ENG-CDR21013-R2-CDs.pdf Markup Summary

E PLAN BRIARGATE BLVD BRID

C212

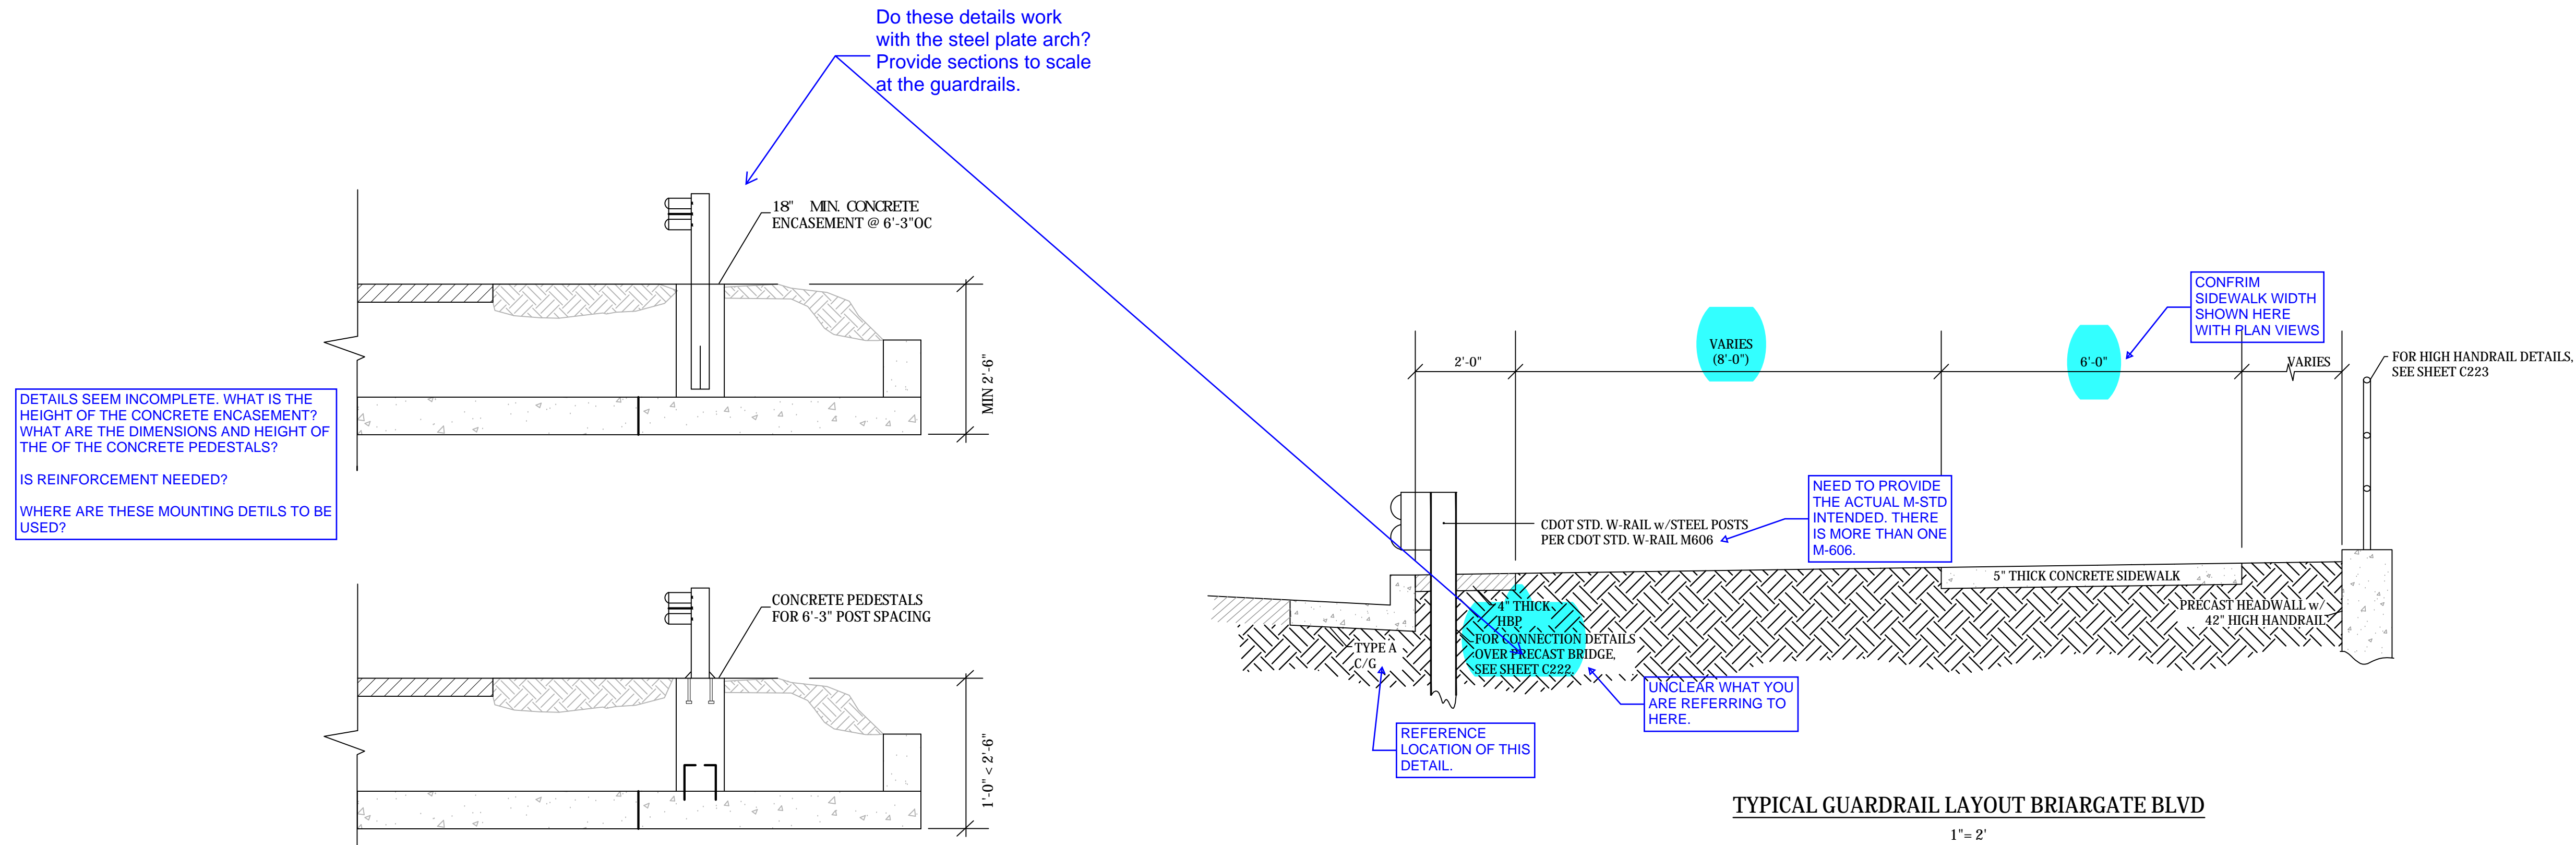
Do these details work with the steel plate arch?
Provide sections to scale at the guardrails.

DETAILS SEEM INCOMPLETE. WHAT IS THE HEIGHT OF THE CONCRETE ENCASEMENT? WHAT ARE THE DIMENSIONS AND HEIGHT OF THE OF THE CONCRETE PEDESTALS?
IS REINFORCEMENT NEEDED?
WHERE ARE THESE MOUNTING DETILS TO BE USED?

**C302**

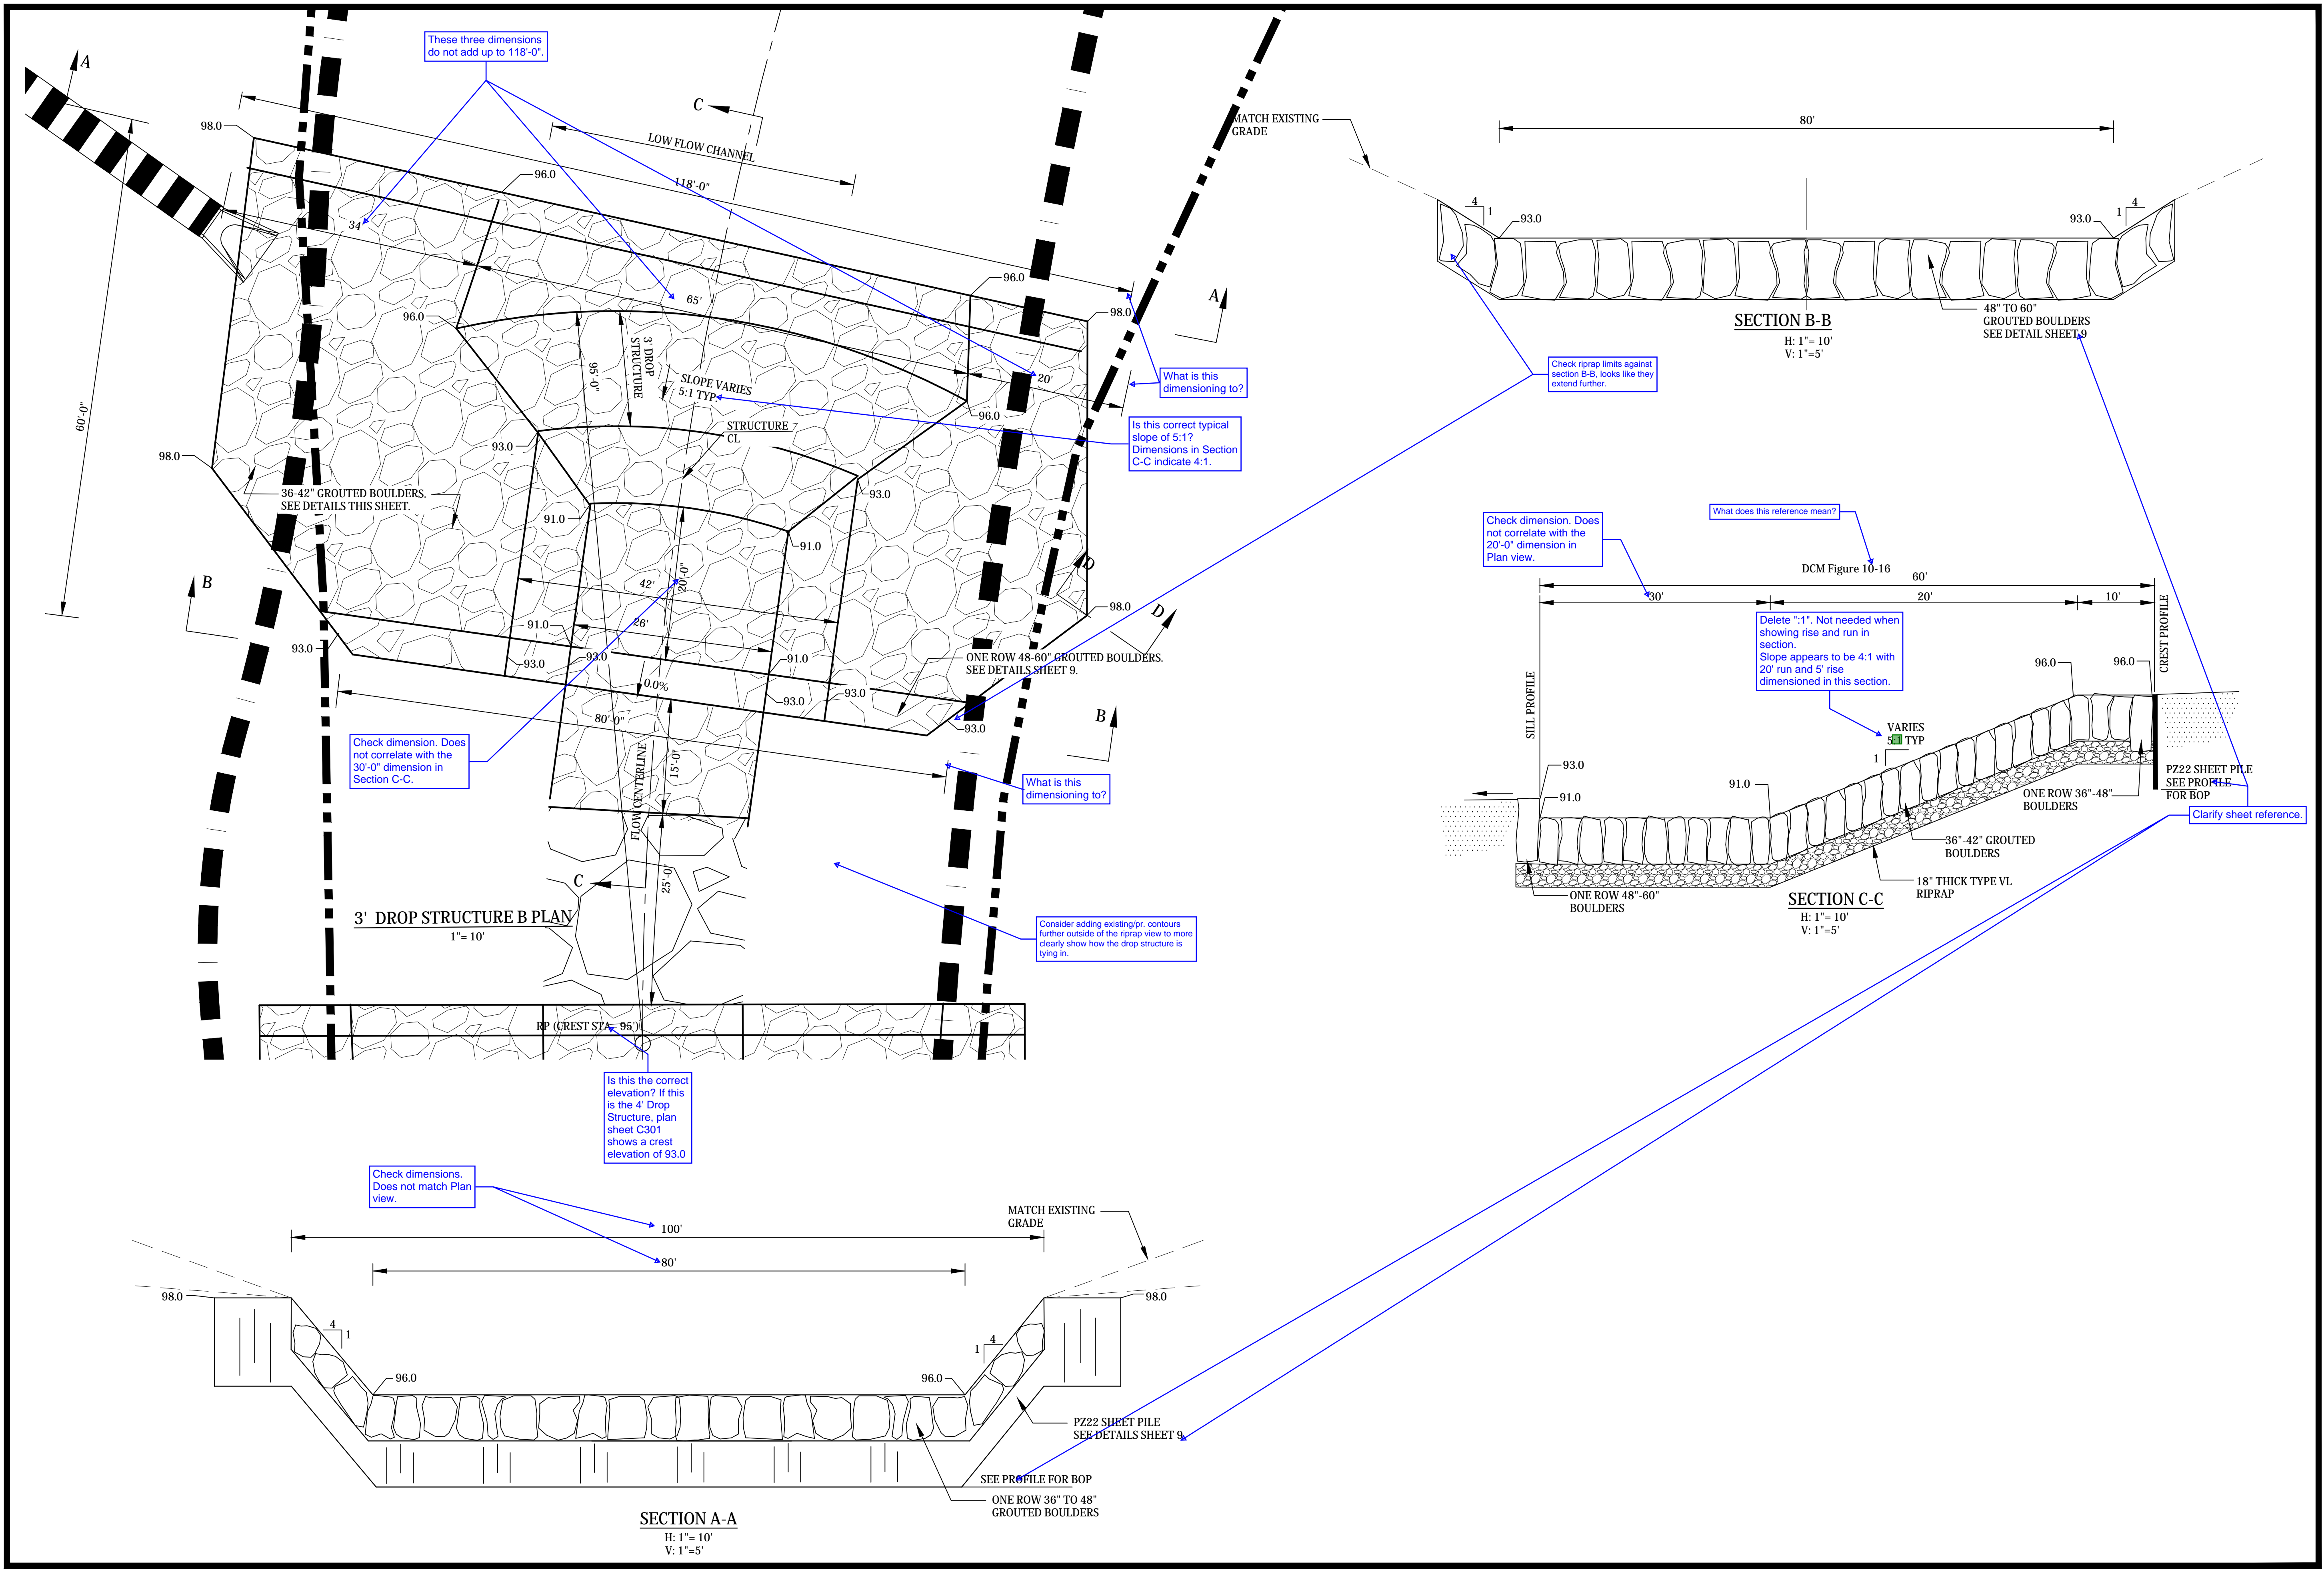
MOVE GRADE CONTROL PILE TO THE CORRECT STATION IN THIS VIEW.
